A303 Sparkford to Ilchester Dualling Scheme TR010036

6.3 Environmental Statement Appendix 4.2 Scoping Opinion Schedule of Comments and Responses

**6.3 Environmental Statement
Appendix 4.2 Scoping Opinion Schedule of Comments and
Responses**

100
90
80
70
60
50
40
30
20
10
0

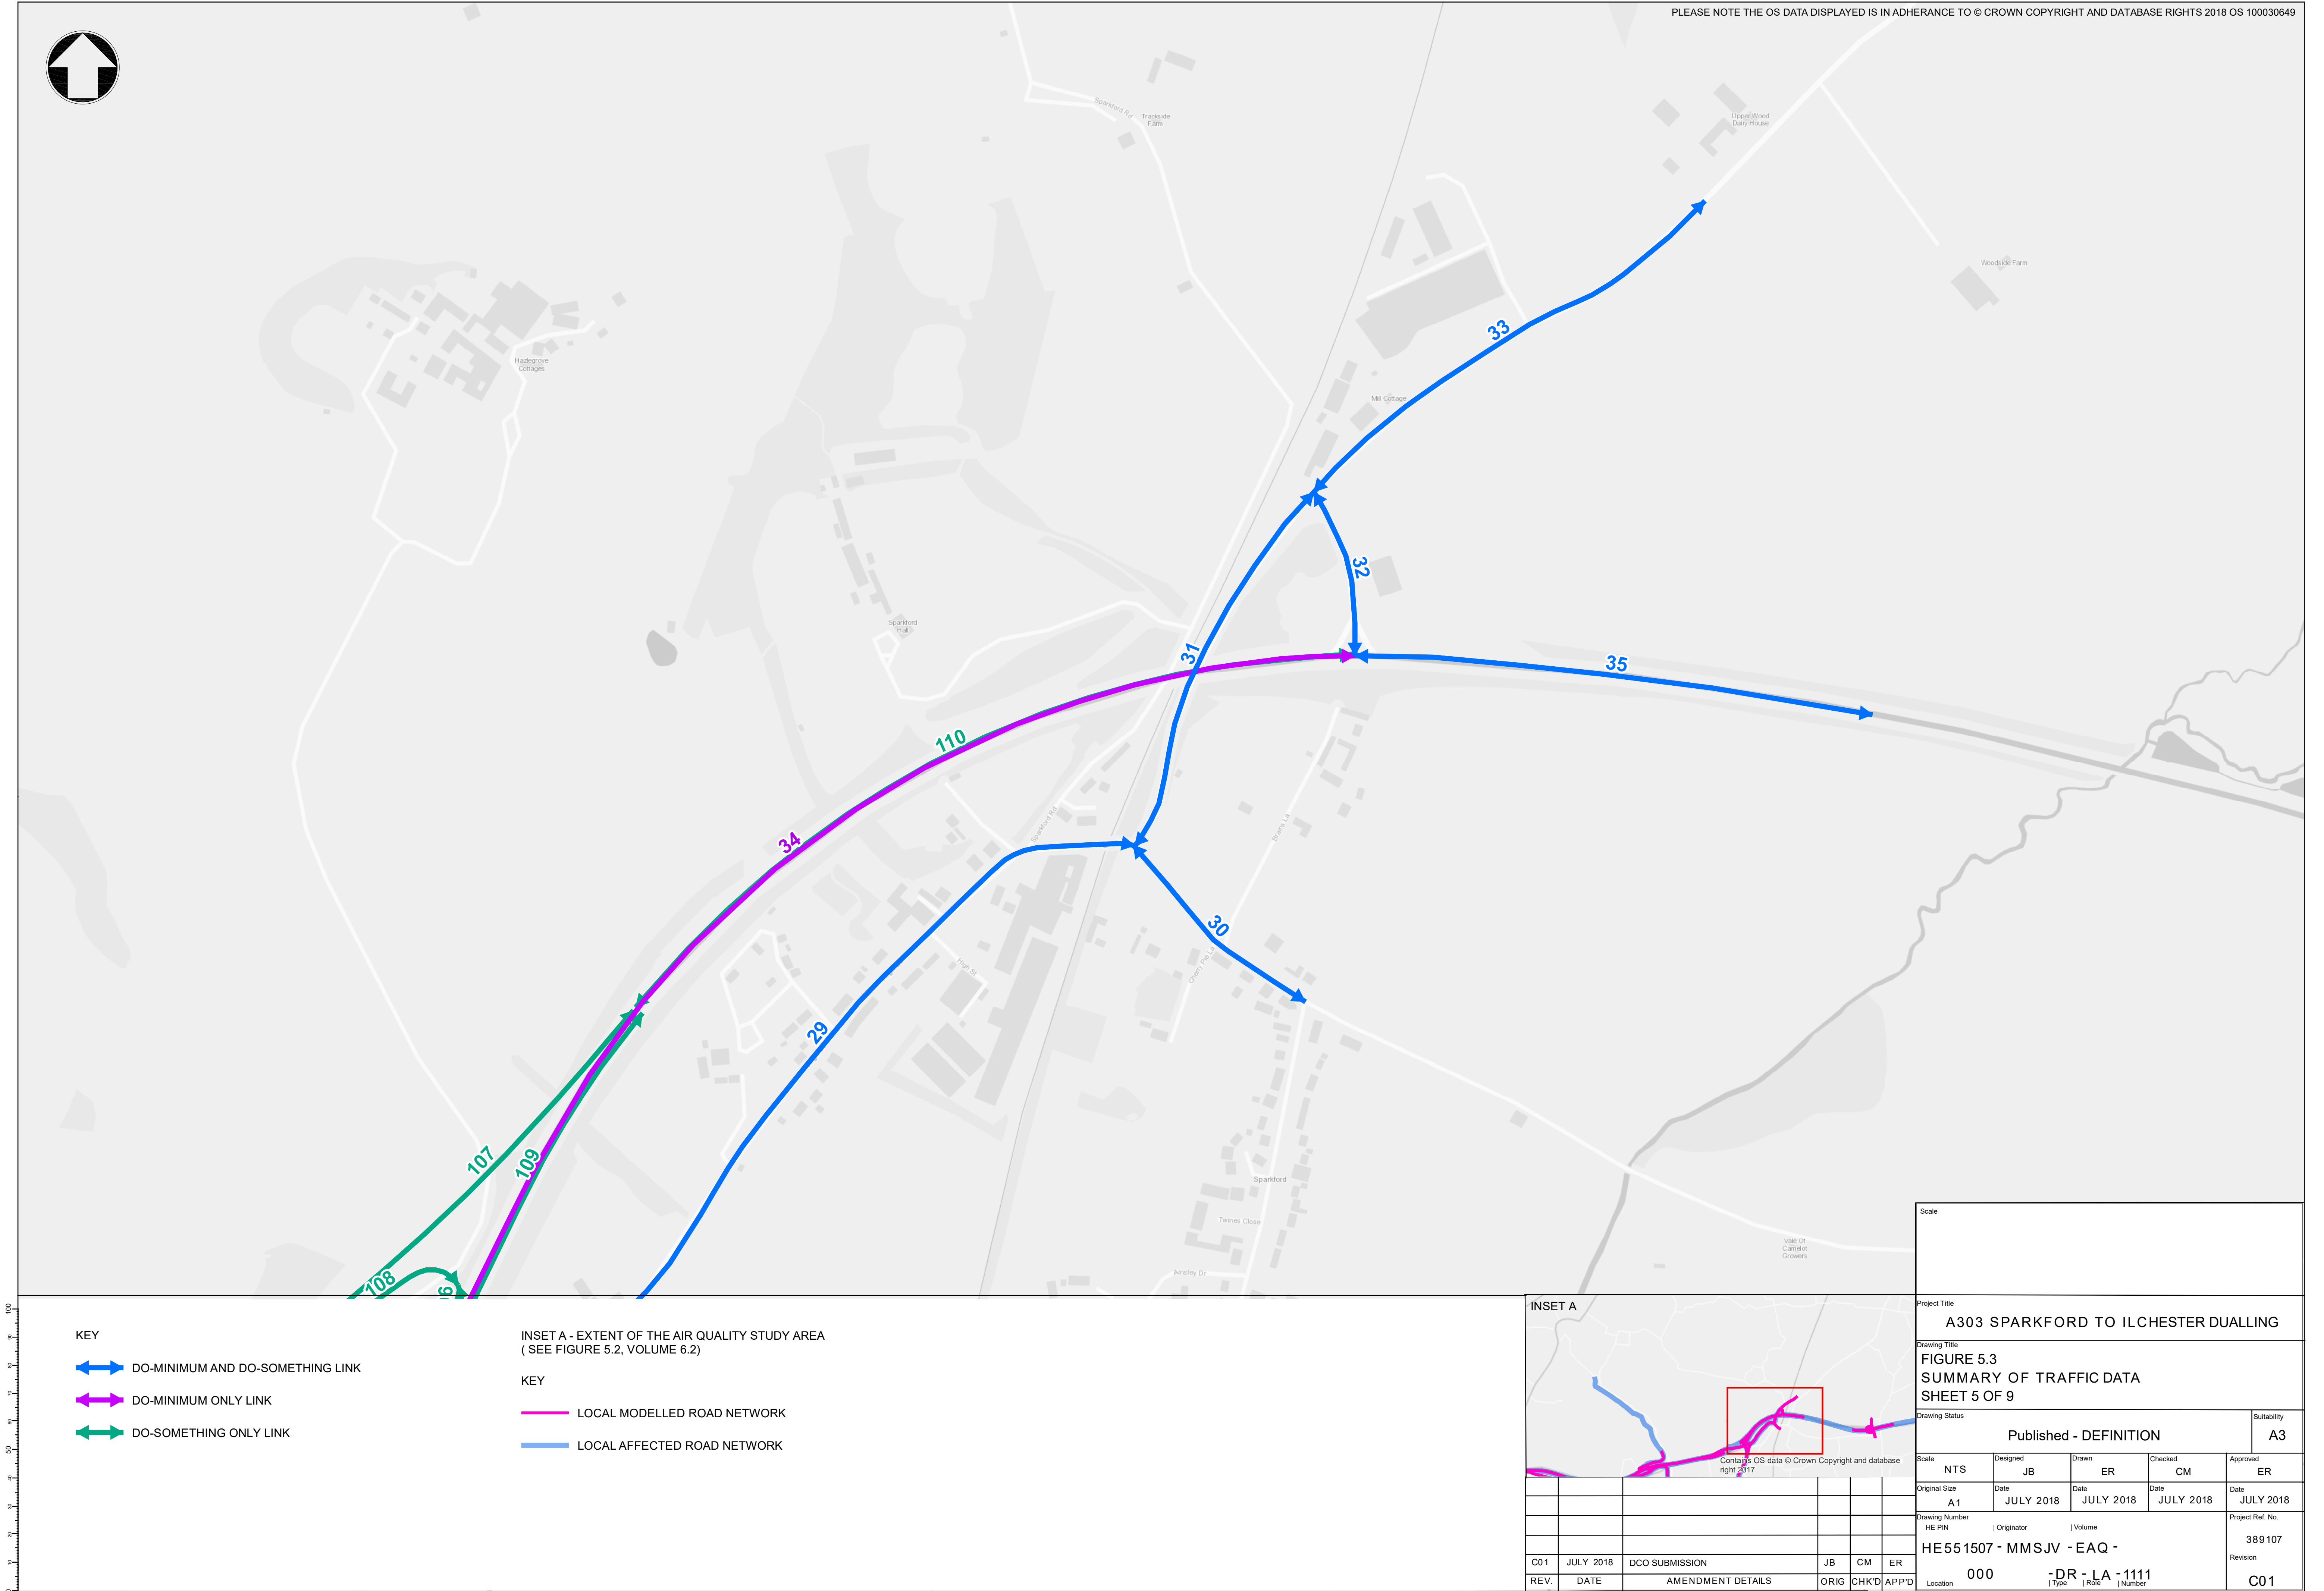
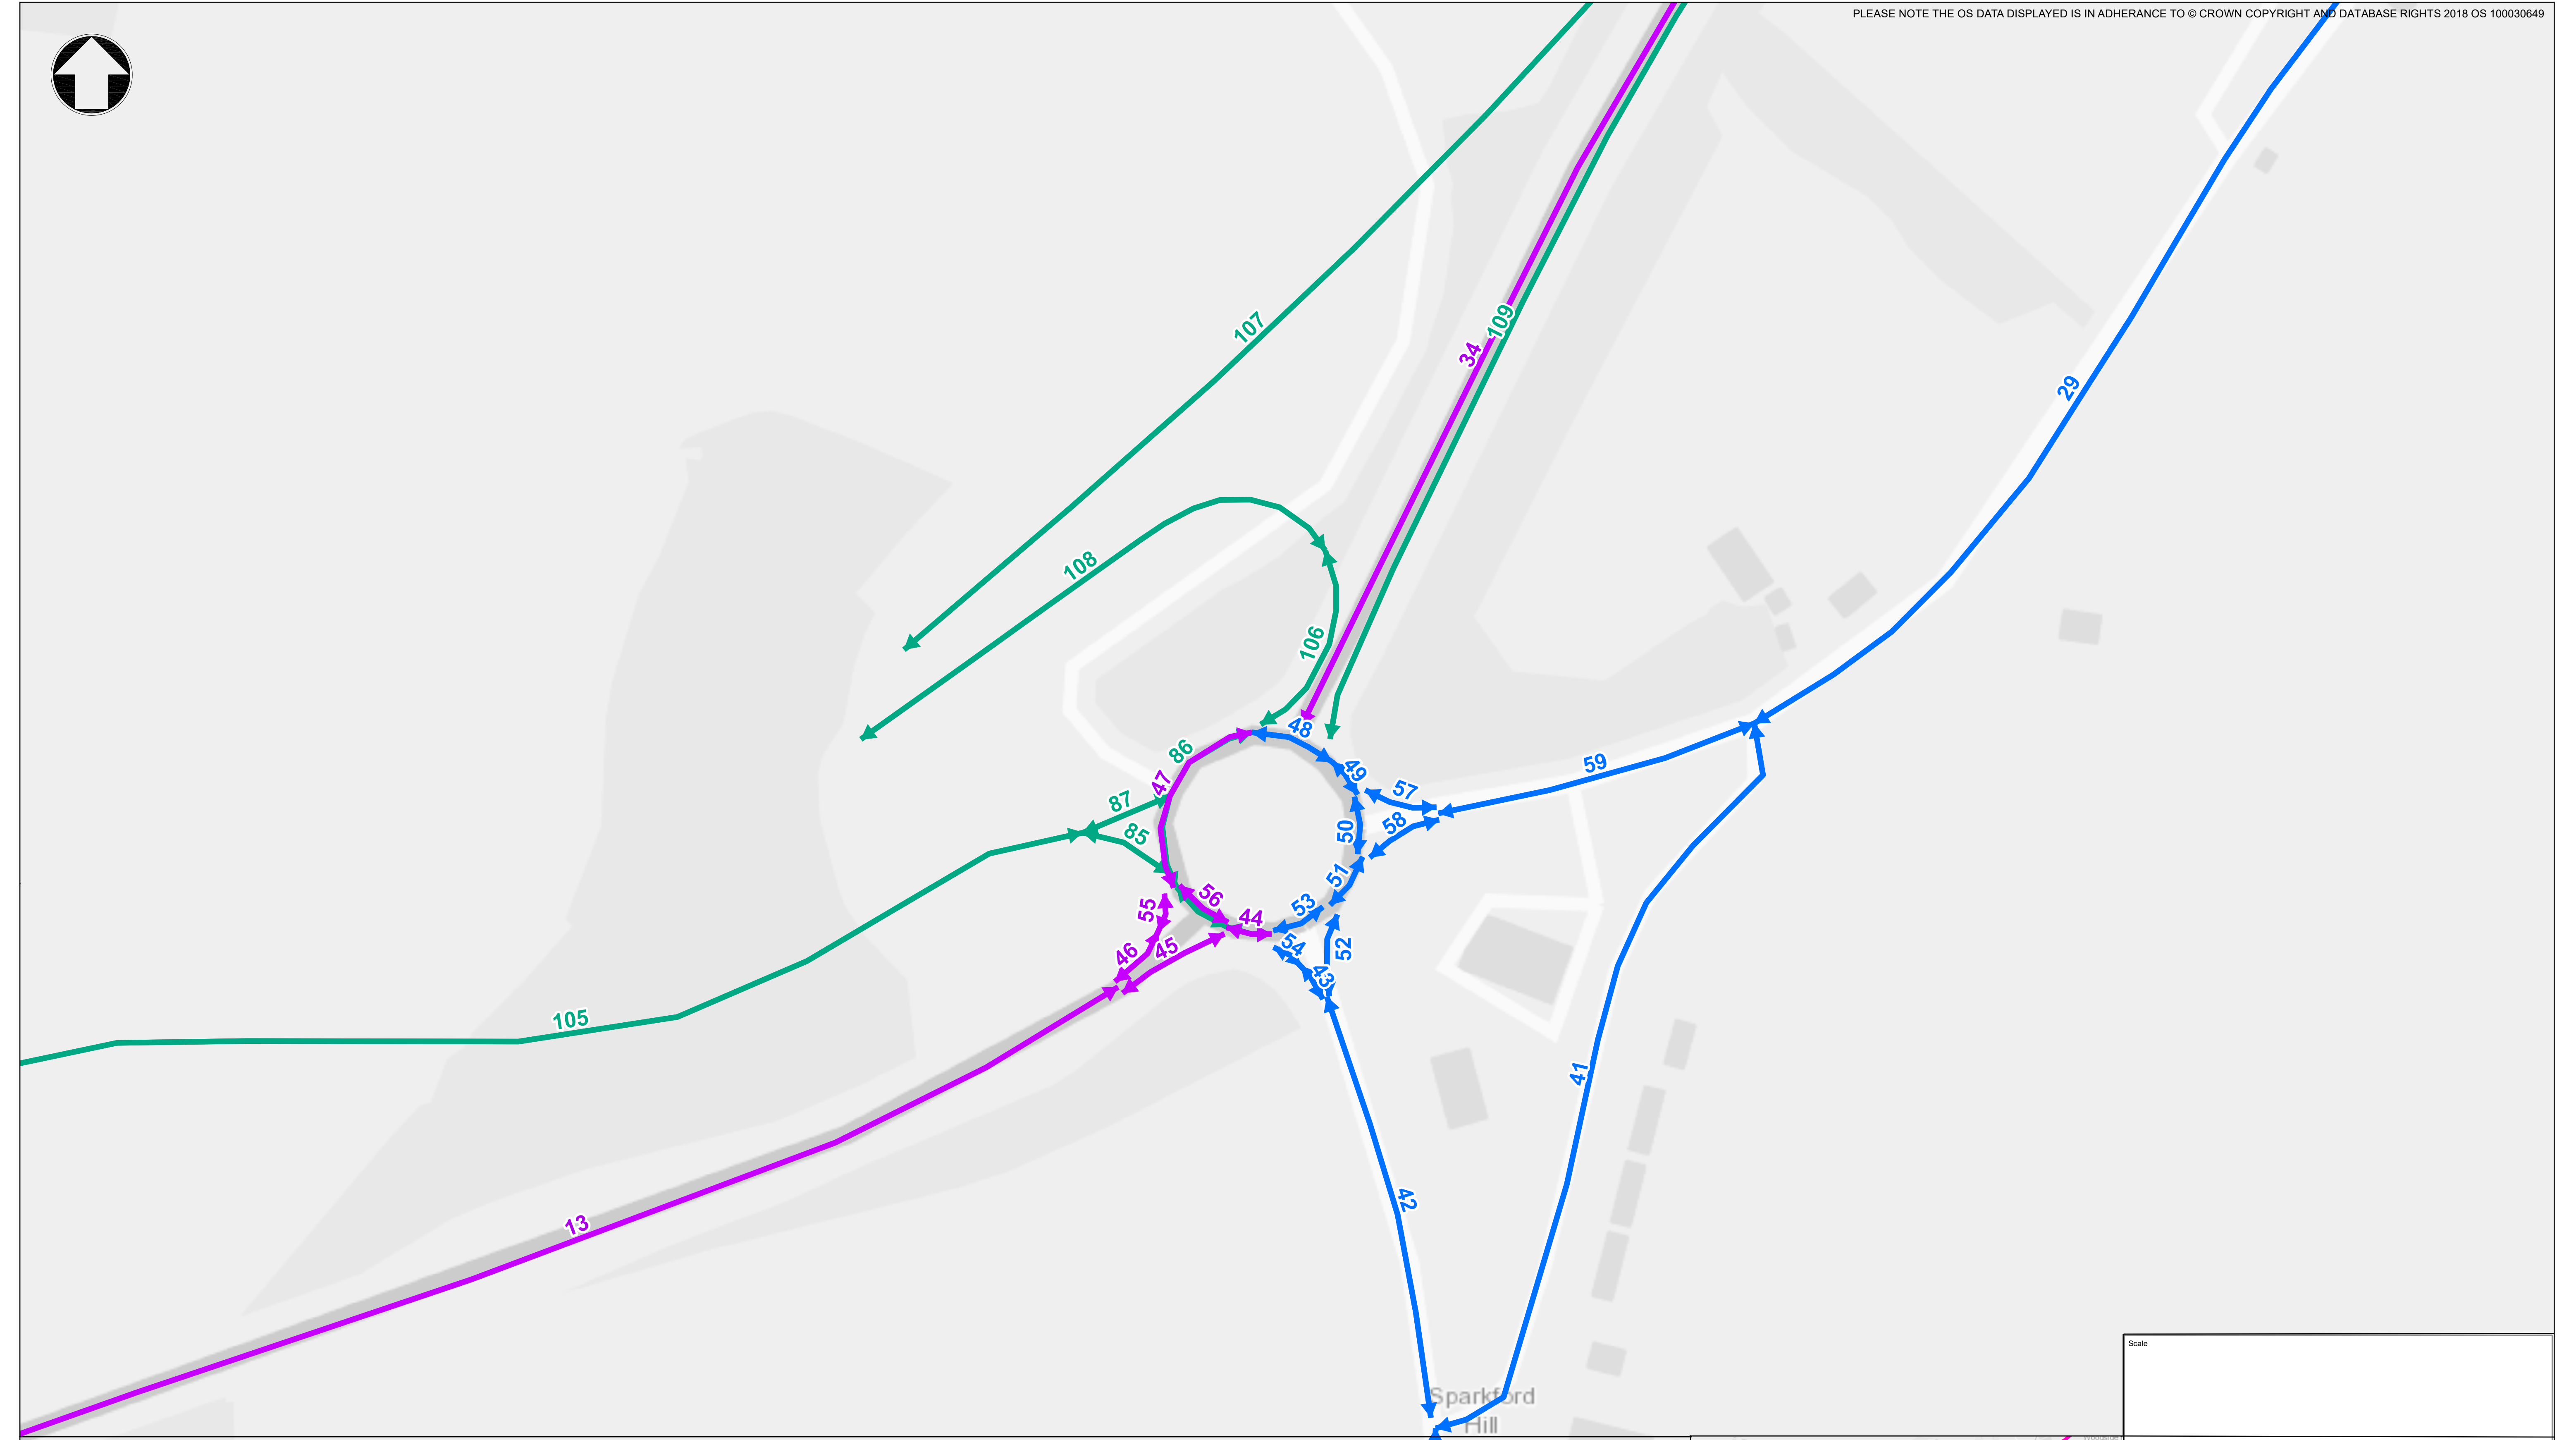
ID 3	PINS	<i>Study area</i> - The ES should include a plan or figure to depict the extent of the ARN and identify the sensitive receptors; both human and ecological which may be impacted by the Proposed Development.	A figure to be included within the ES of the ARN and nearby sensitive receptors.	Figure 5.2 shows the Local ARN, 5.5 shows the Regional ARN, and Figure 5.4 shows the air quality receptors (both air quality and ecological) considered within Chapter 5 Air Quality, Volume 6.1.
ID 4	PINS	<i>Baseline</i> - The Scoping Report identifies that diffusion tube monitoring has taken place over 6 months at 16 locations along roads near the Proposed Development. The dates of these surveys, together with the locations and justification of why the locations were selected should be included within the ES.	Additional information related to the monitoring survey undertaken to be included in the ES.	Appendix 5.2 Monitoring Survey (Volume 6.3) has been produced to provide additional details on the diffusion tube monitoring undertaken.
